Central Coast Quarter - Stage 1, Northern Tower (SSD-23588910)

Submissions Report

ATTACHMENT 1

DA101
B

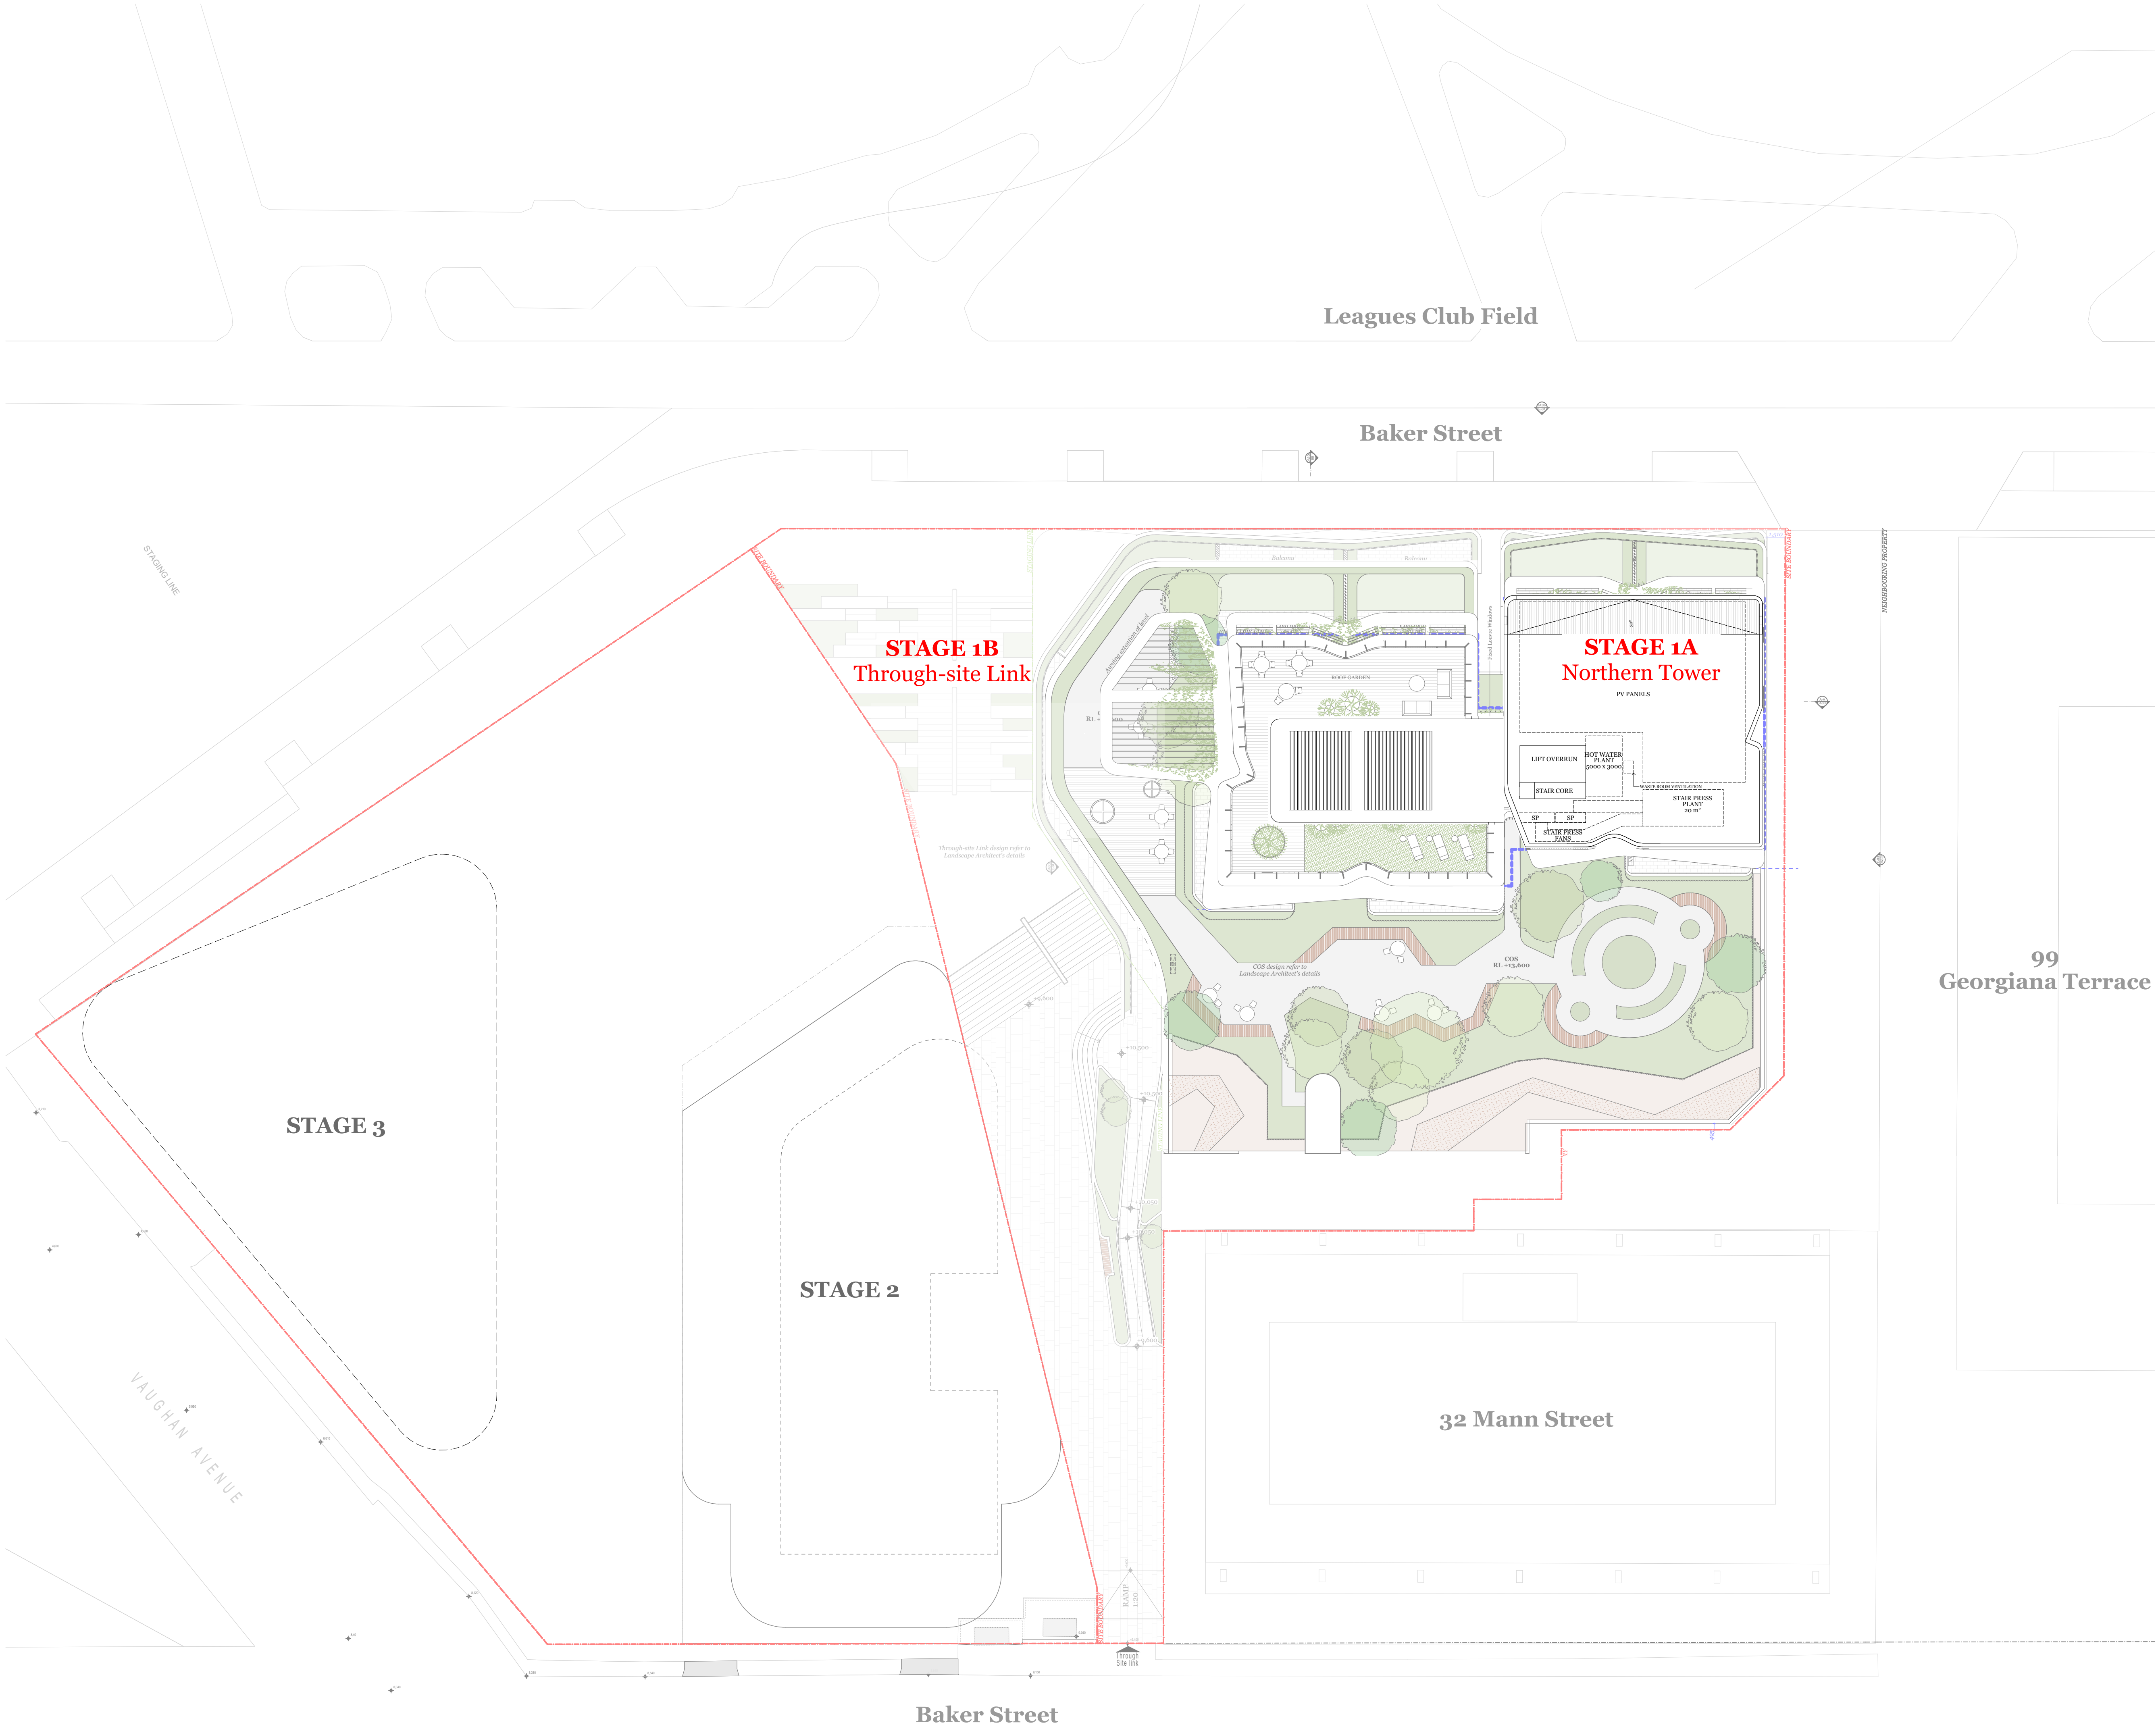
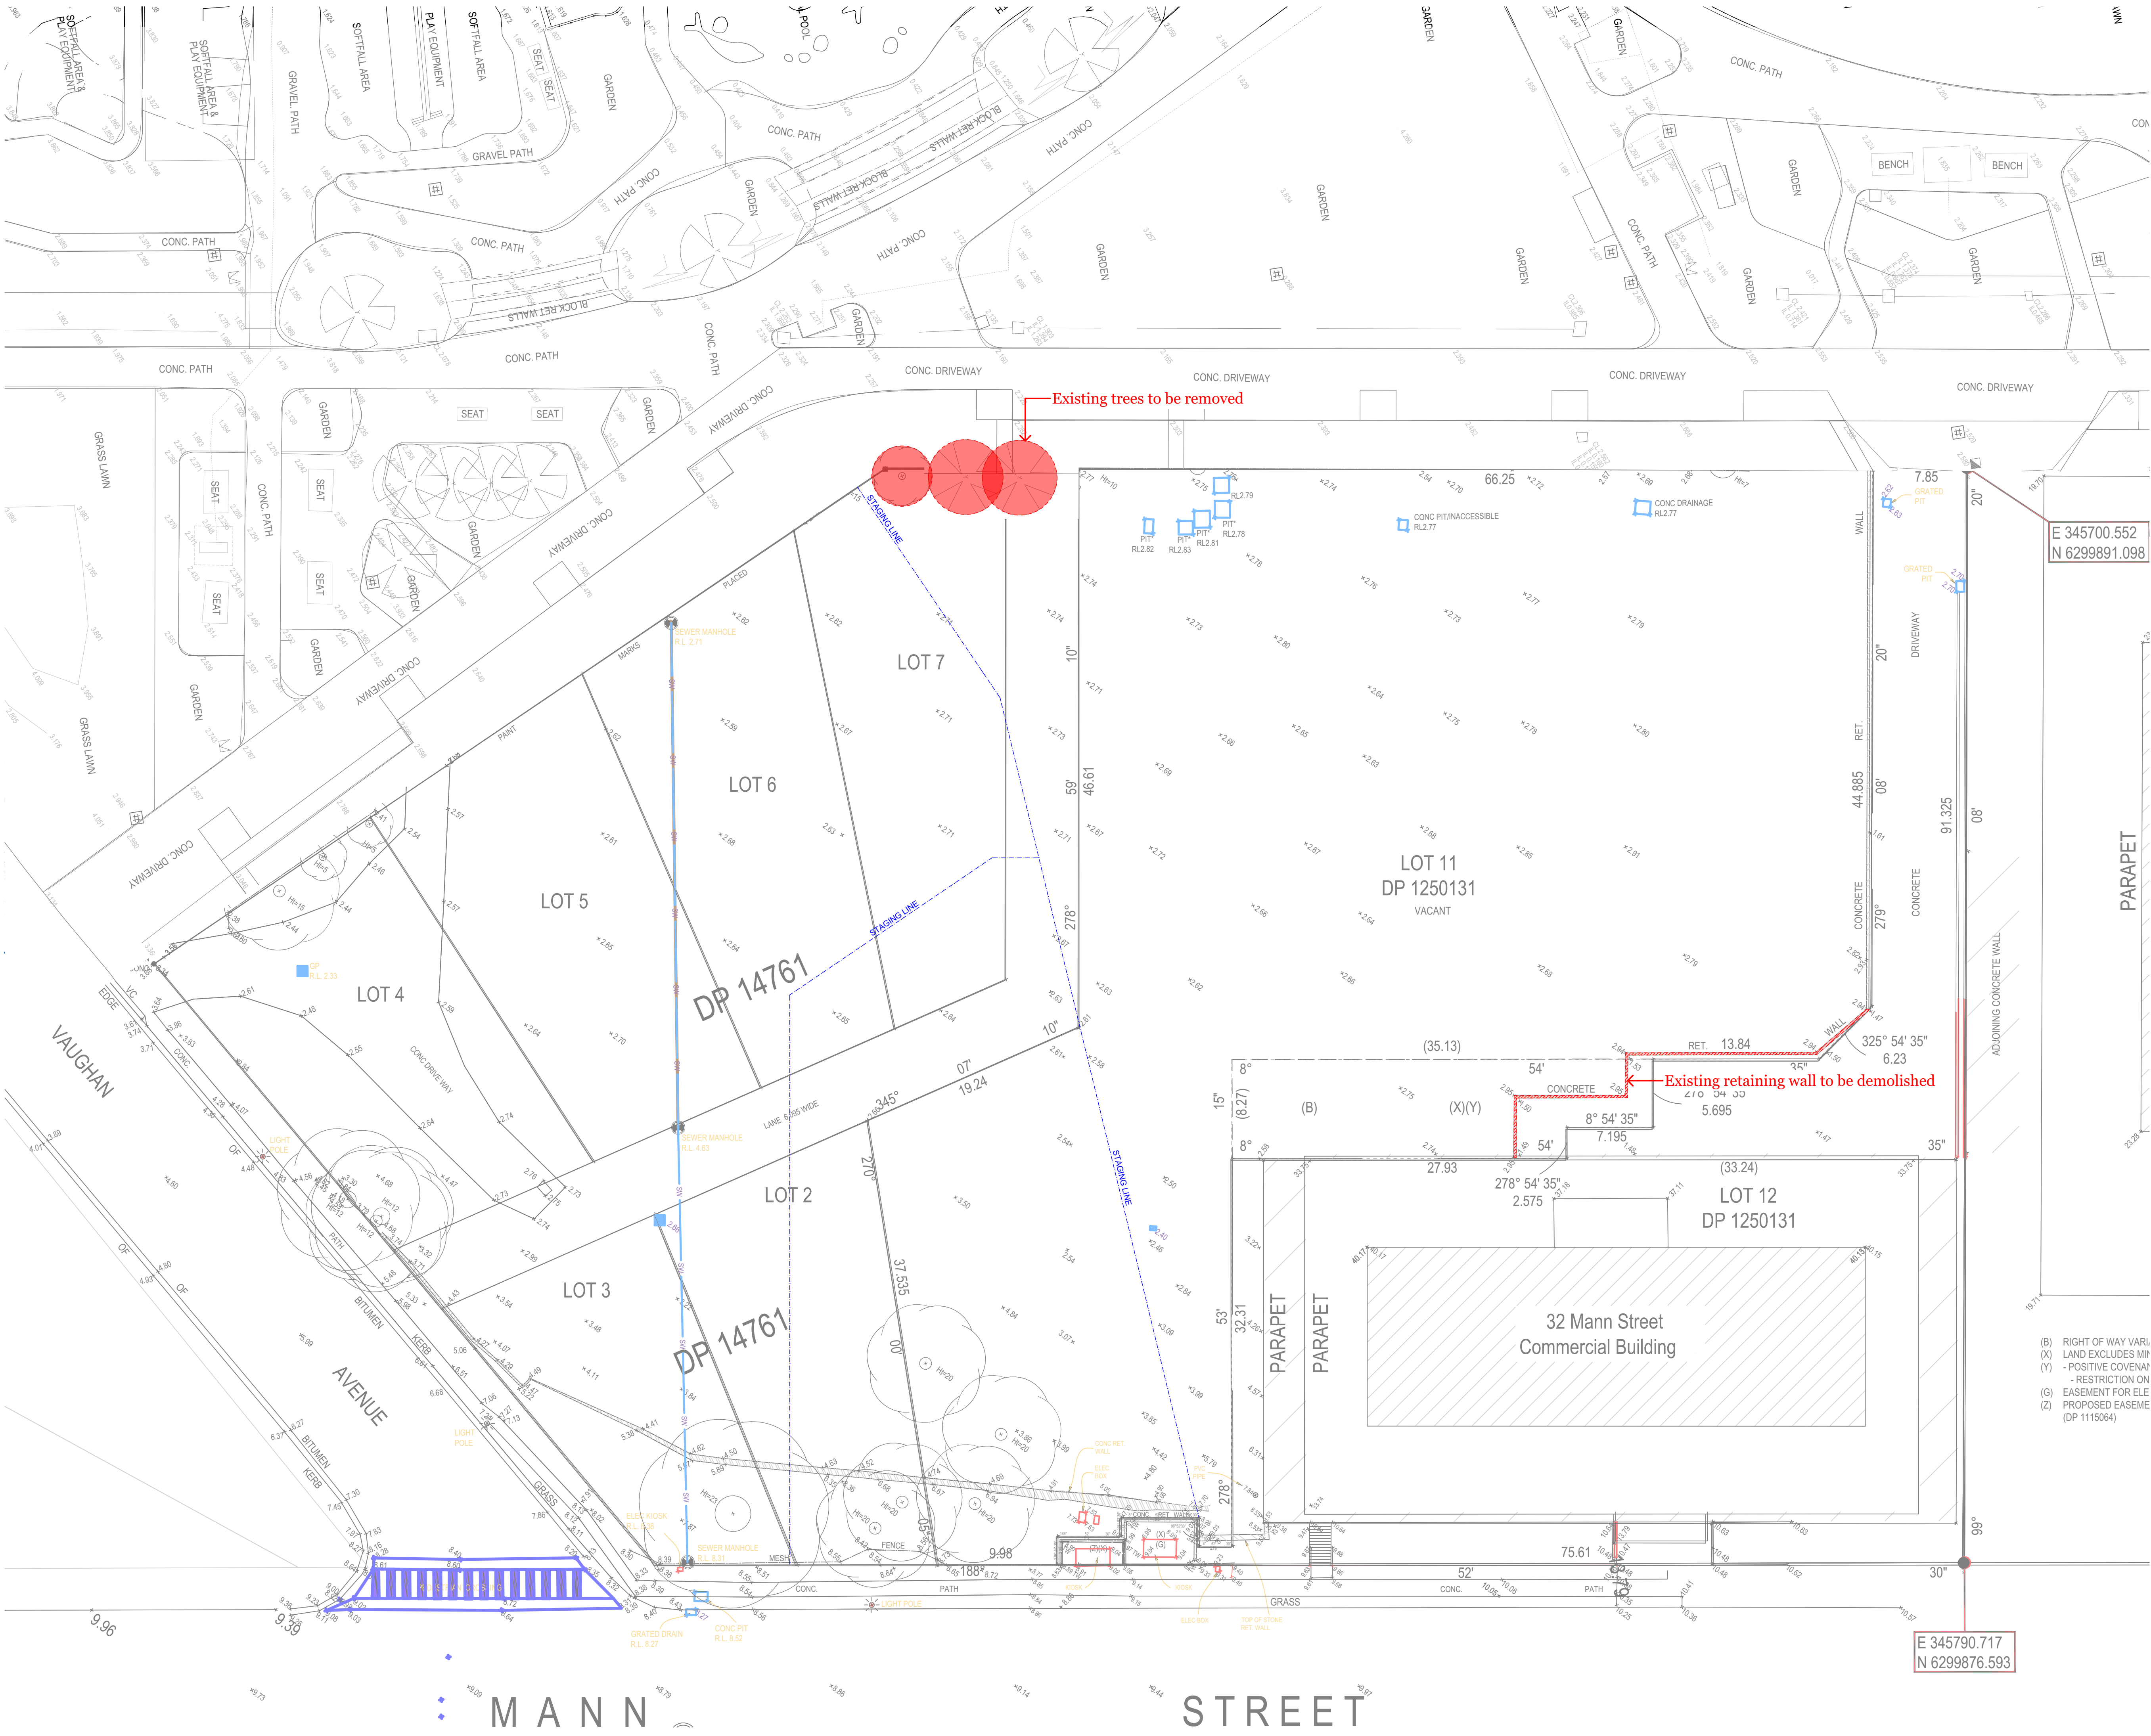
2. The legal description of the site (Lot/DP) quoted in the EIS (page 27) and annotated on the architectural drawings (DA101A and DA103A) is inconsistent. Also, confirm whether the site is known as 26-32 (to), 26 & 32 Mann Street or another address (noting it only relates to Stage 1 and not the entire Concept Approval site).

Elevations & Sections
West Elevation (Baker Street)

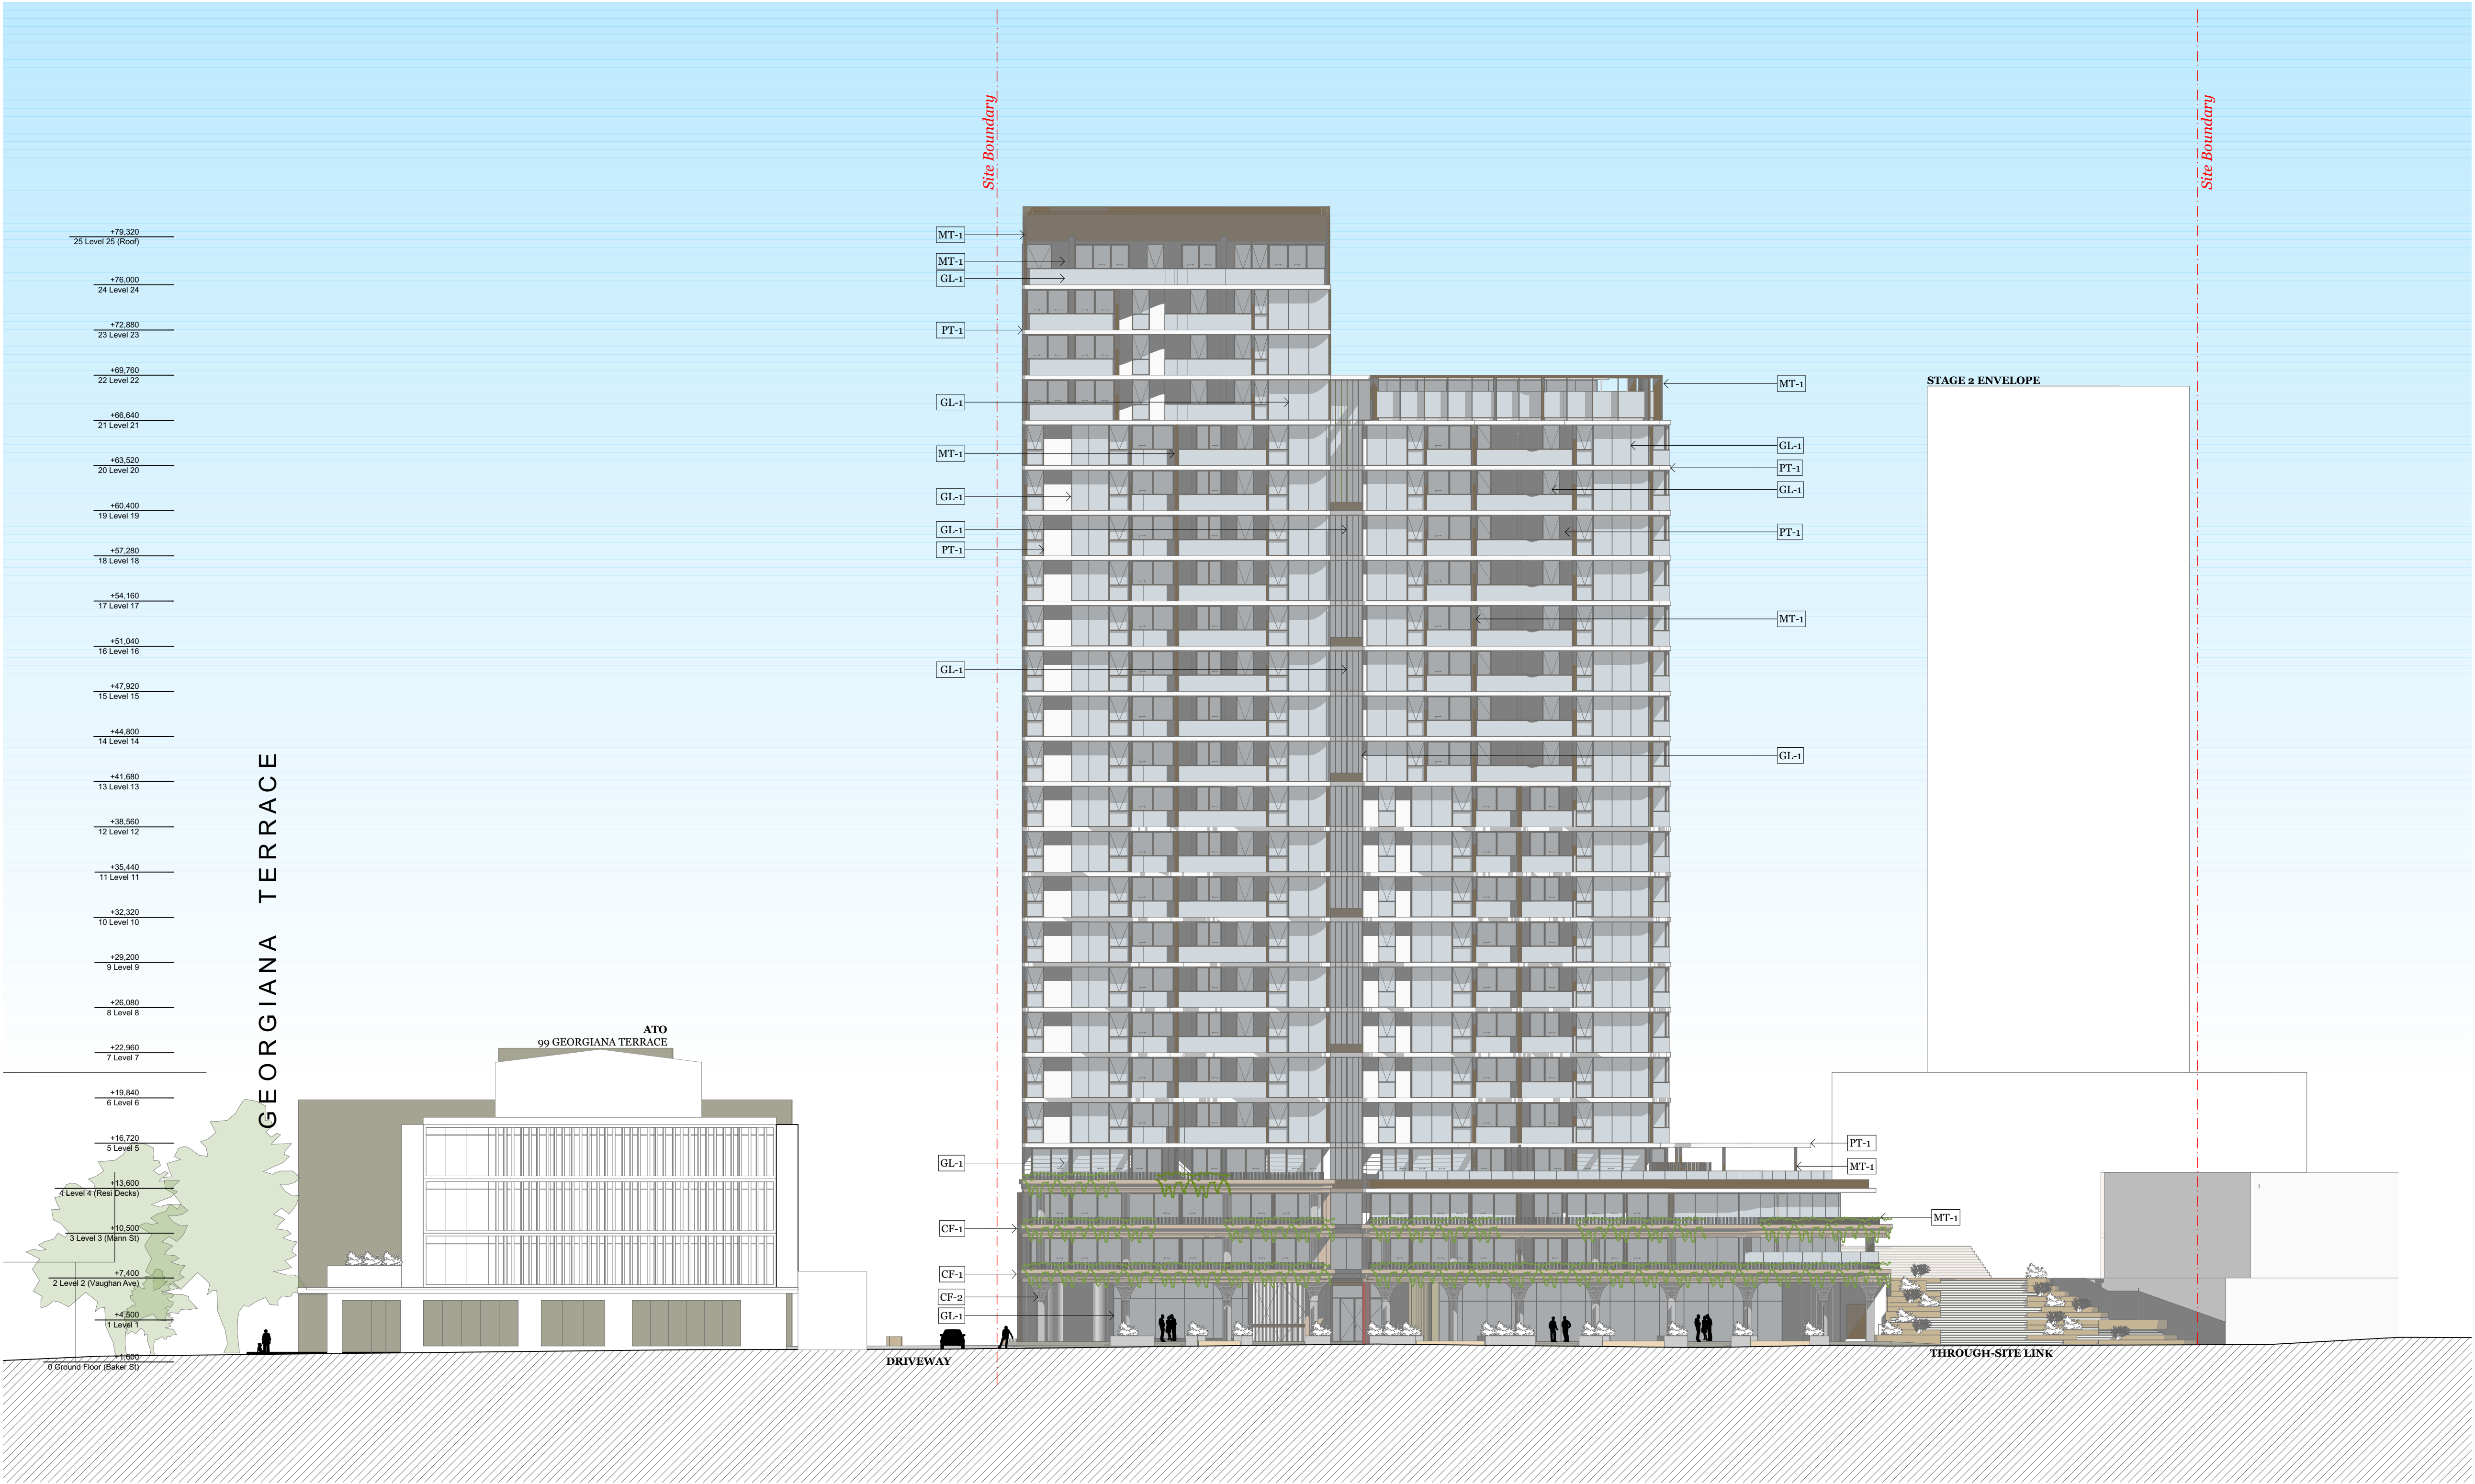
4. Clarify the likely visual impacts of the implementation of the key wind mitigation measures. In particular:
 - a) update the Baker Street elevation CGIs (pages 67 and 68 of the Design Report) to show the wind mitigation measures, including the 1.2m impermeable balustrades, 2.4m impermeable screen (grounds and level 1) and 1.8m impermeable screen on top of planters and 2m intertenancy screen (level 4)
